Written Representation Summary – Hedenham Parish

**Observations & Objections submitted in
response to East Pye Solar Farm Site 10 proposal**

Hedenham Parish Meeting
Updated October 2026

Figure 11.7: Likely and Suitable Routes to the Scheme

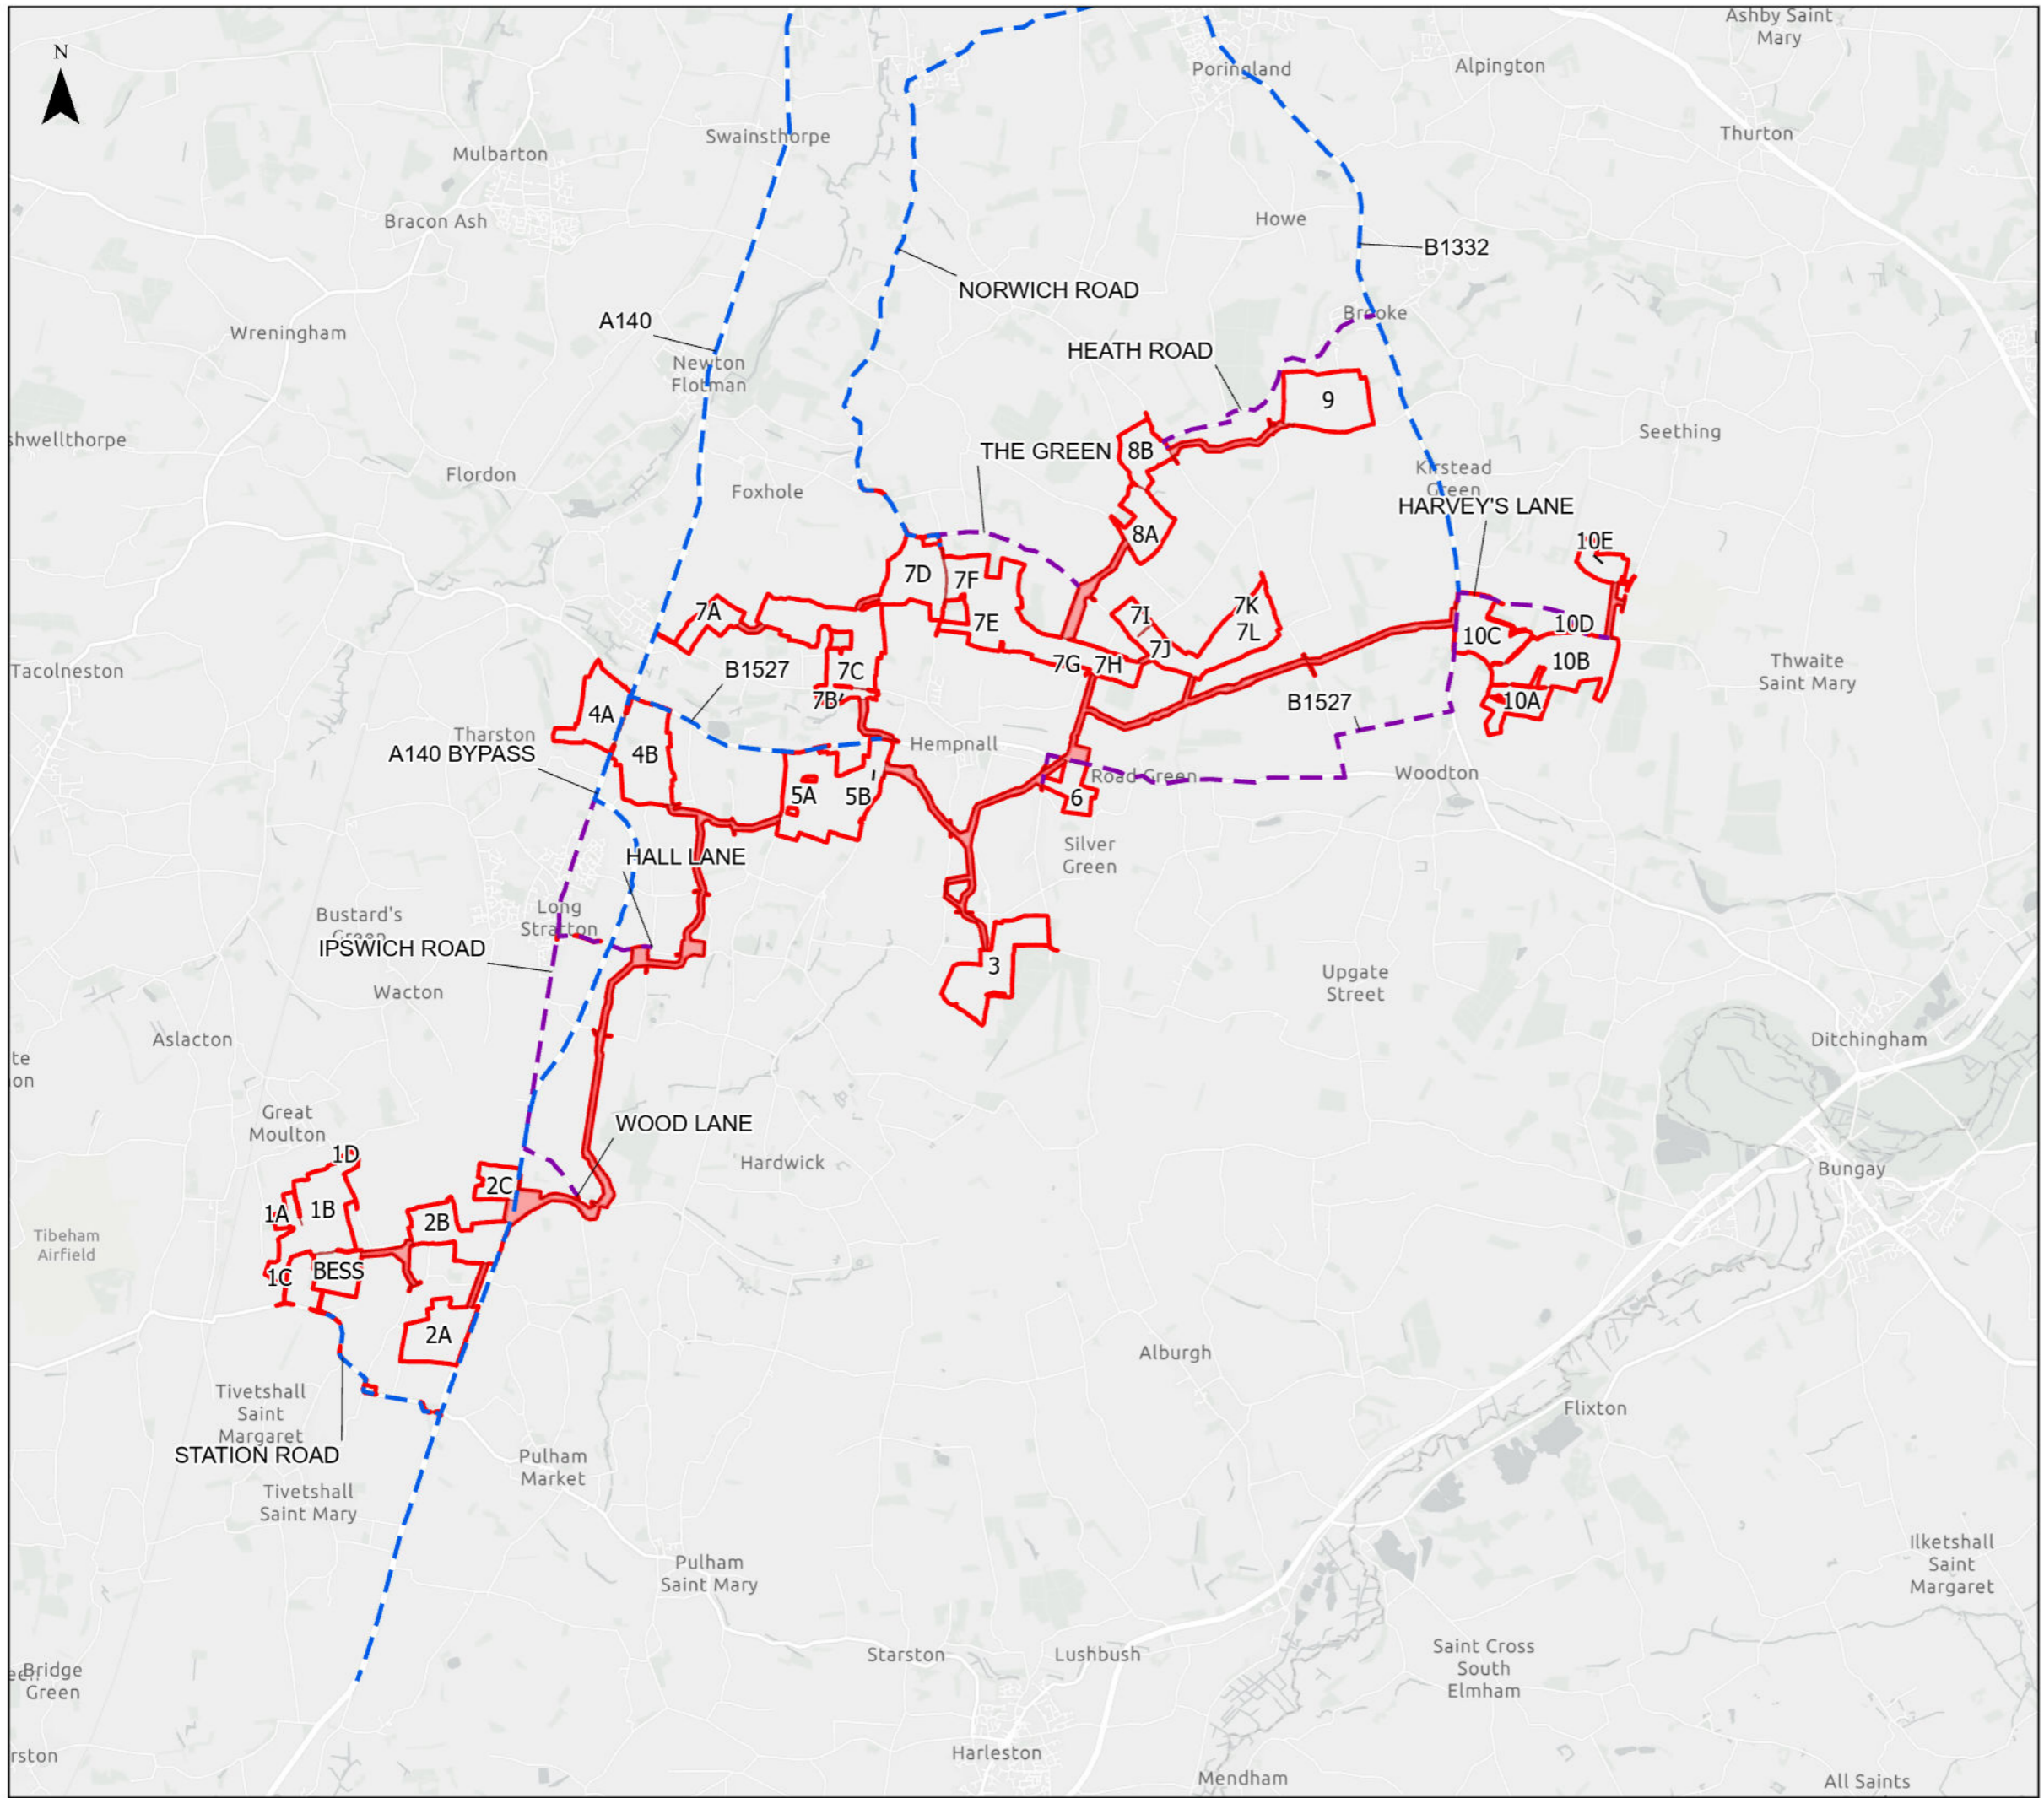
5. Sub-site 10A has no acceptable access route and should be removed from the Scheme.
6. There are no documented provisions to manage the run-off water from Site 10 and the flooding risk it poses to Woodton village which already has existing flooding problems.
